# TRAFFIC IMPACT STUDY

**I68 Training Facility Development**  
**El Paso County, Colorado**  
PCD File No. PPR2440

October 2024  
Revised December 2024

A conceptual site plan is shown on Figure 2. This plan is provided for illustrative purposes only.

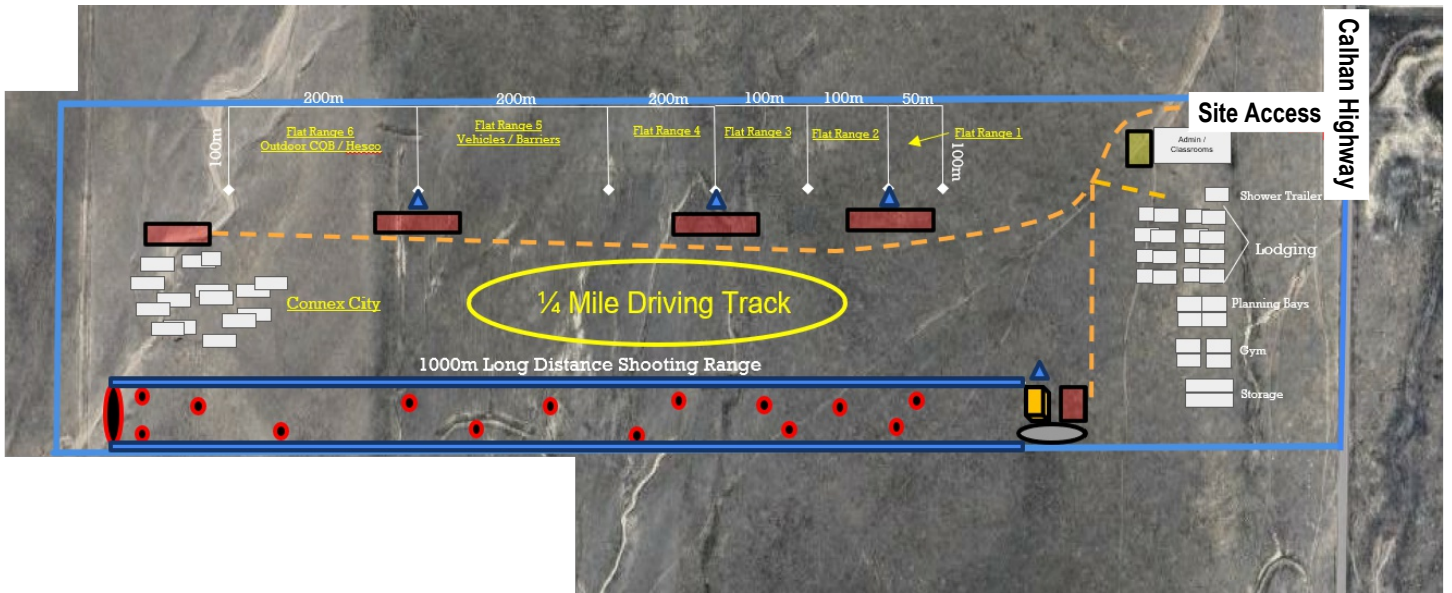
Please account for all uses in phase 4. The letter intent includes lodging, admin building, gym, driving track etc. Please see comment below regarding the phasing of the development.

Please be aware that per the site development plan the connex city will be done at a later phase(4). Traffic analysis can be broken up into the proposed phases to see whether the aux. turn lane is triggered with what is only currently proposed. Feel free to call to discuss.

It is emphasized that lodging, admin building, gym, driving track, etc. are ancillary uses to the overall development, as described on previous page.

As a result, per meeting held with County Staff on January 7, 2025, this review comment is null & void. No revisions needed.

Comment acknowledged.
